SF2018/253369; WST18/00116/08

**SSI9487; Narromine to Narrabri (N2N) Inland Rail Project; Review of EIS**

**Transport for NSW**

Figure A7.5 Connection with the Parkes to Narromine section of Inland Rail

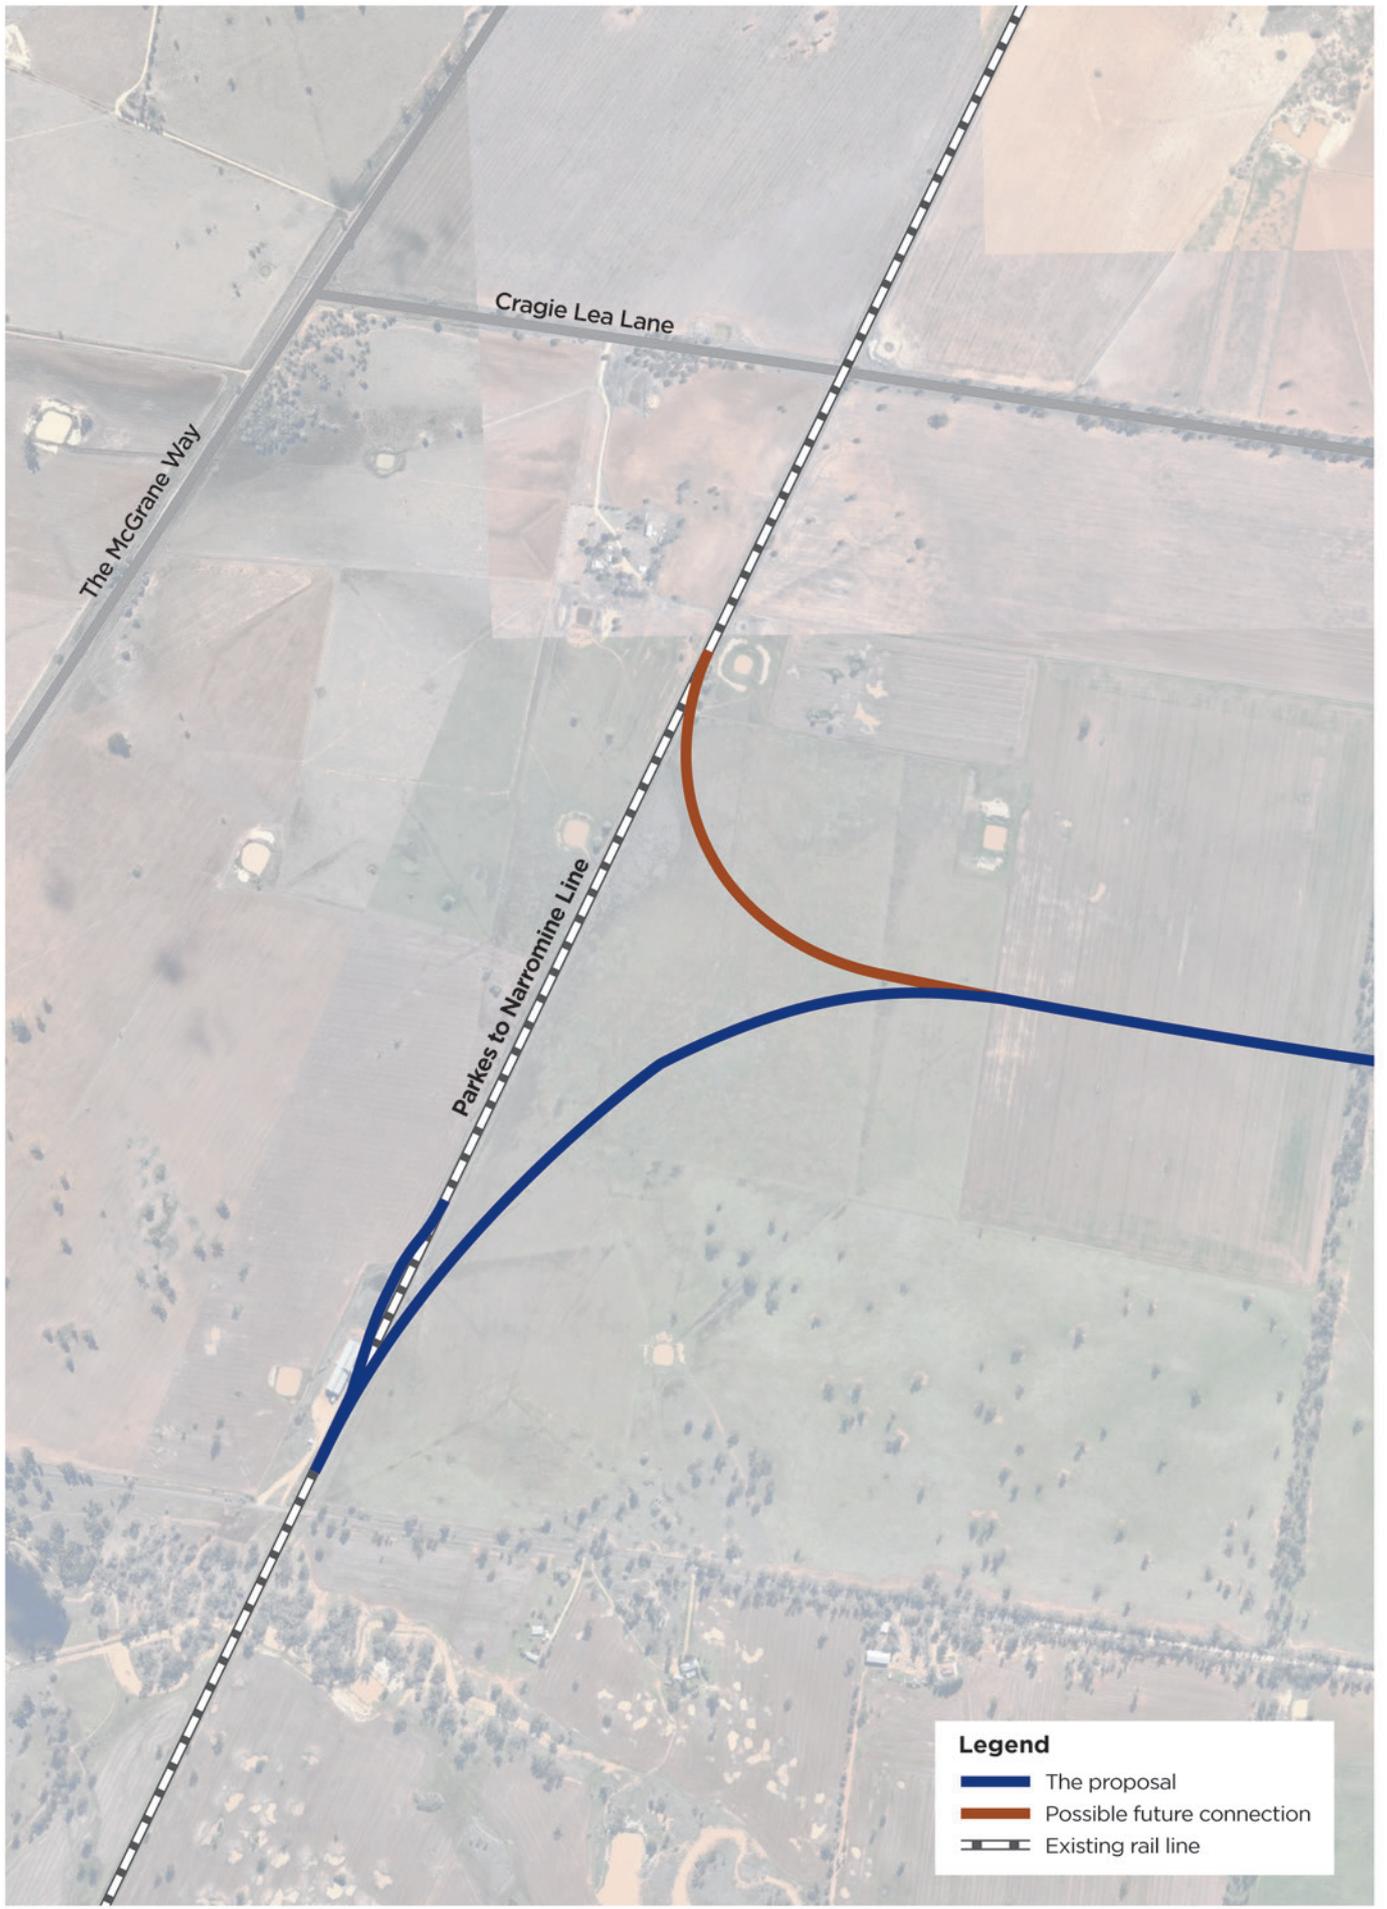
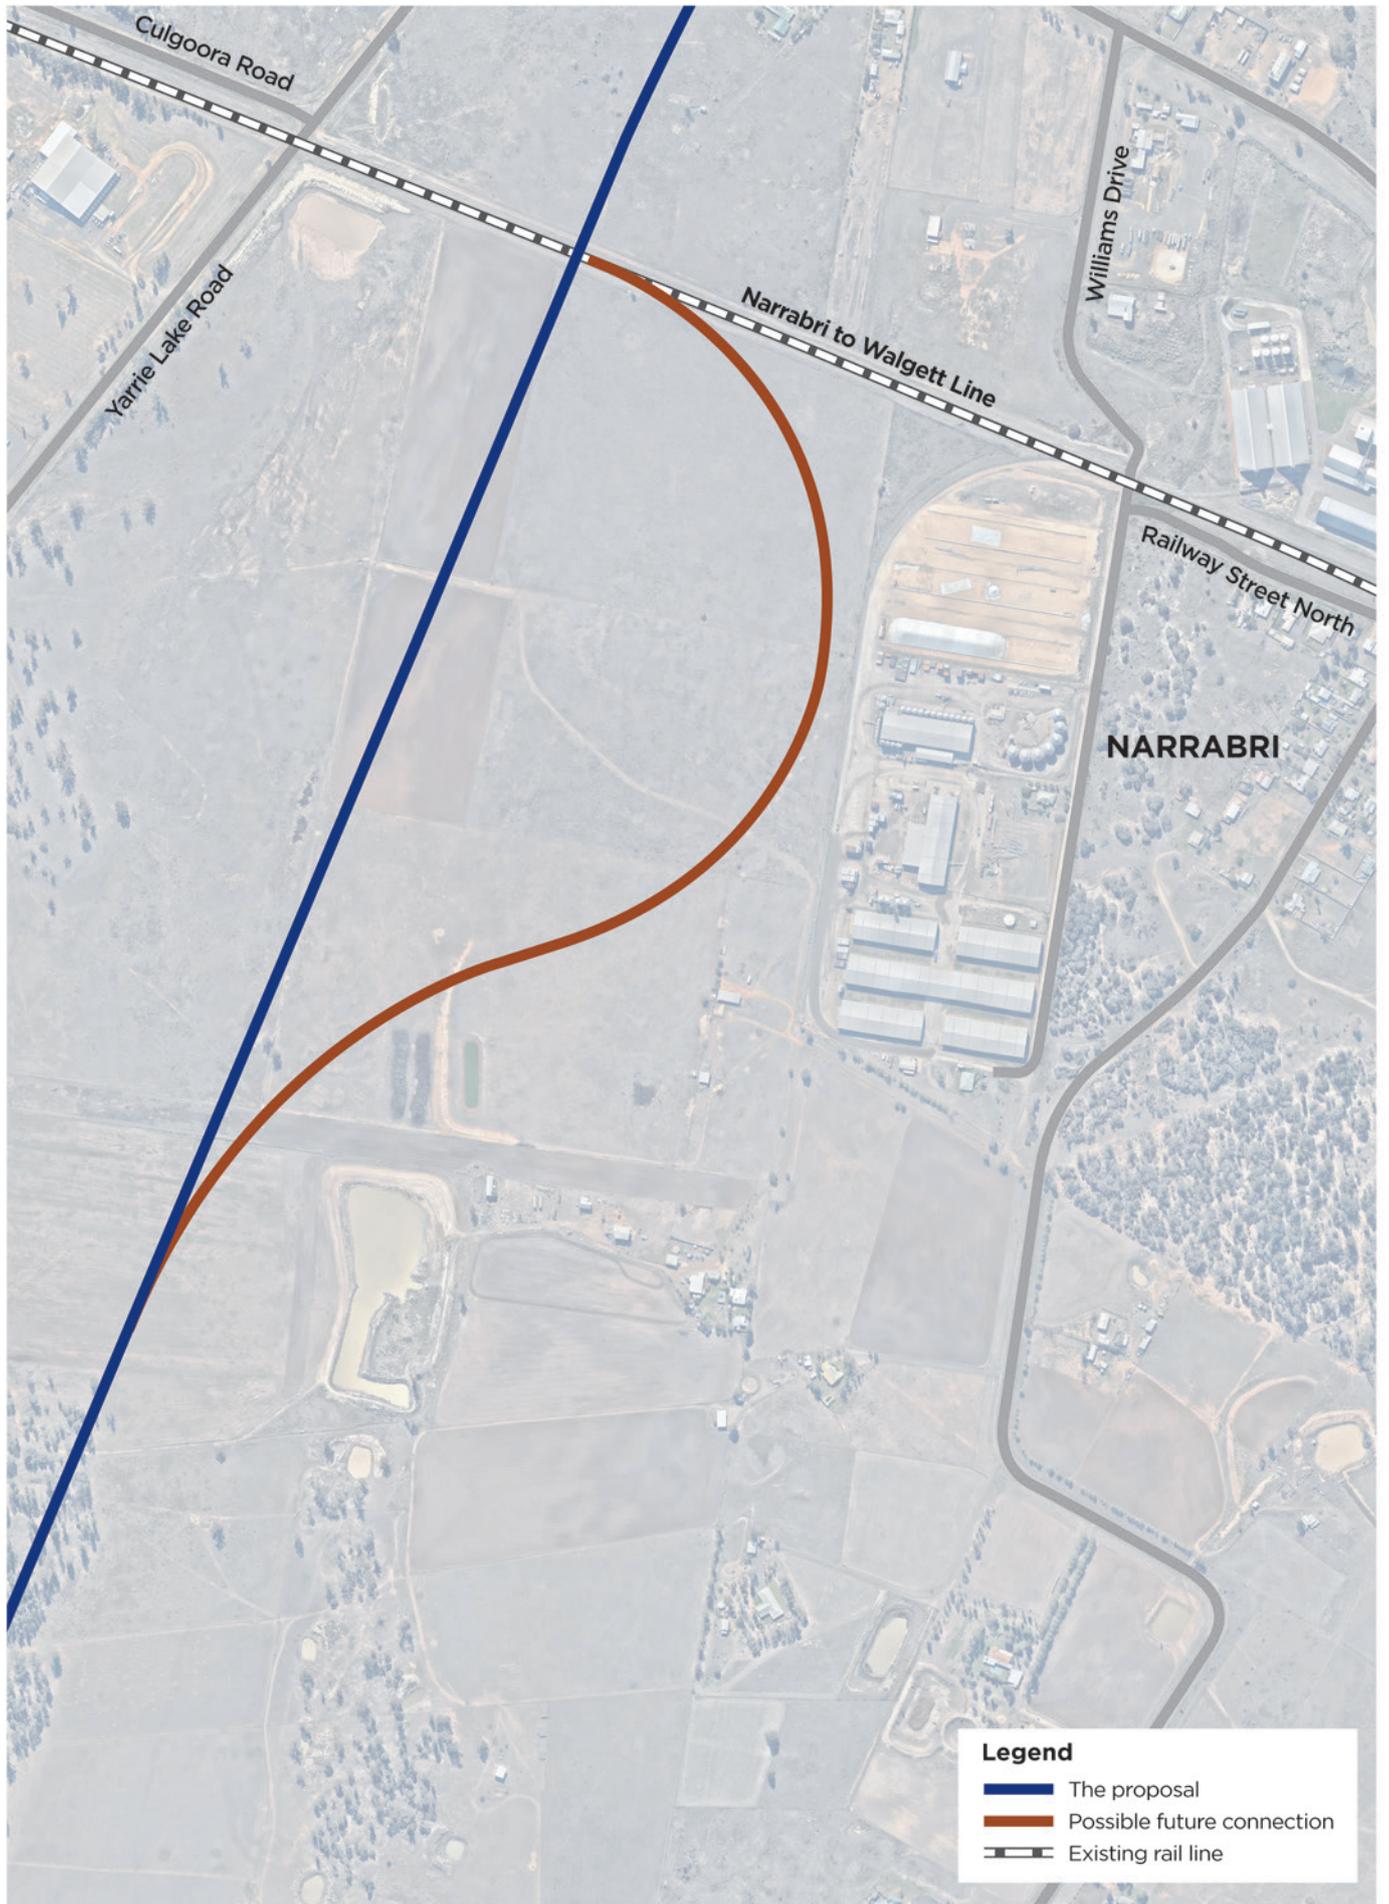
A7-6 & A7-9	A.7.3.5 & A7.3.6	Narromine West connection and connections with other rail lines are inconsistent.	Part E Maps and Parts 4 and 5 are inconsistent and require alignment.

Figure A7.9 Level crossings (map 1)

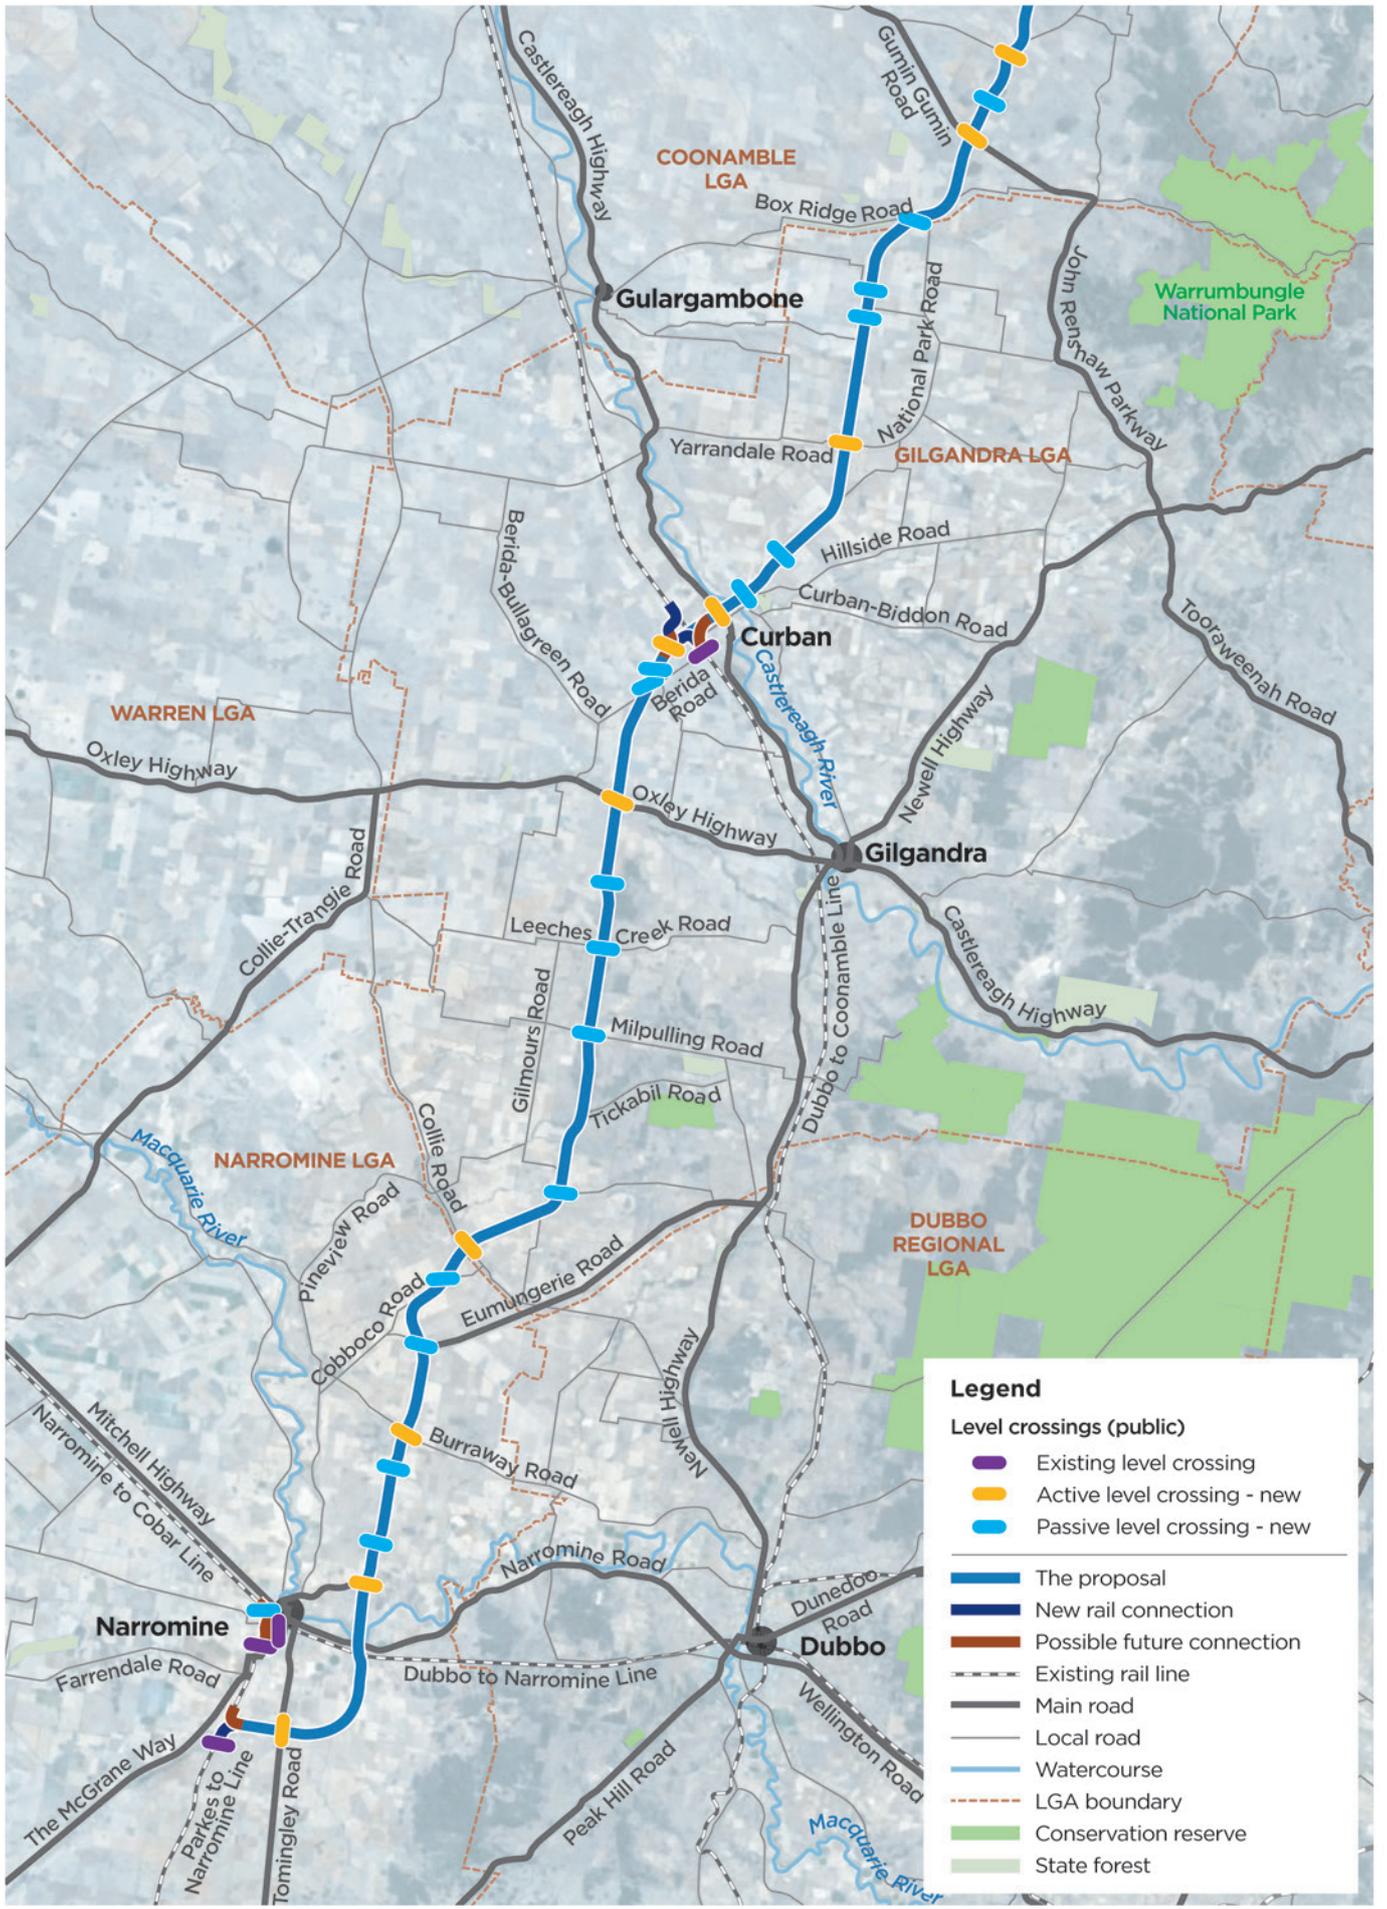
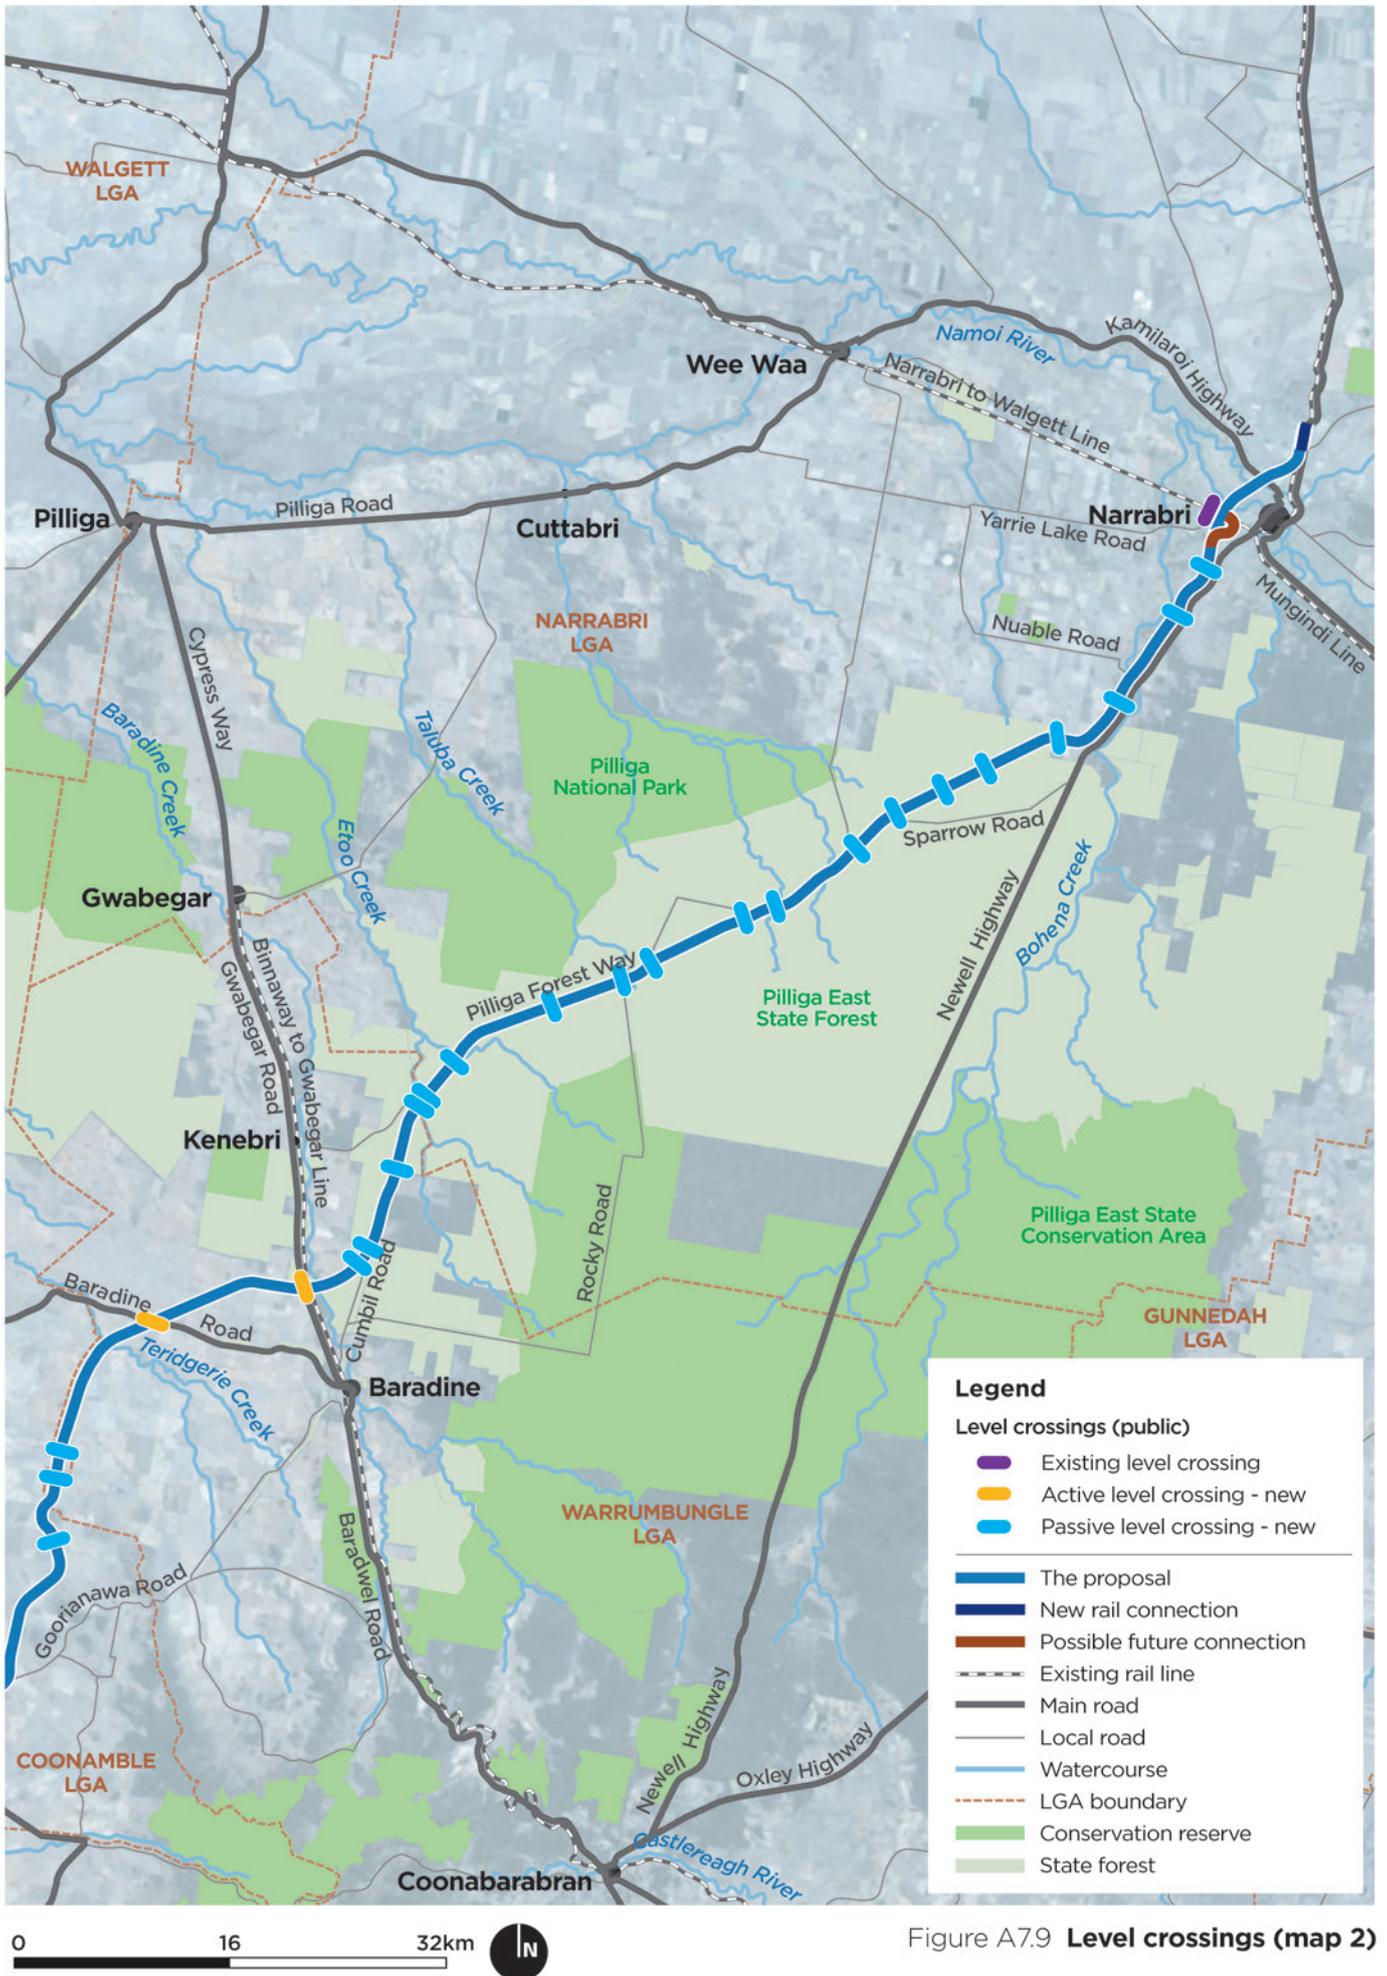
TfNSW has reviewed the submitted documentation and notes the proposal still includes six at grade crossings of classified roads. TfNSW, in its previous submissions, has clearly stated that all new Inland Rail interfaces with classified roads are to be grade separated. As such, TfNSW objects to the proposal, as submitted in relation to treatment of the road rail interfaces (level crossings).

TfNSW is willing to reconsider its position, subject to amended information being provided for review that provides for grade separated interfaces of classified roads and Inland Rail.
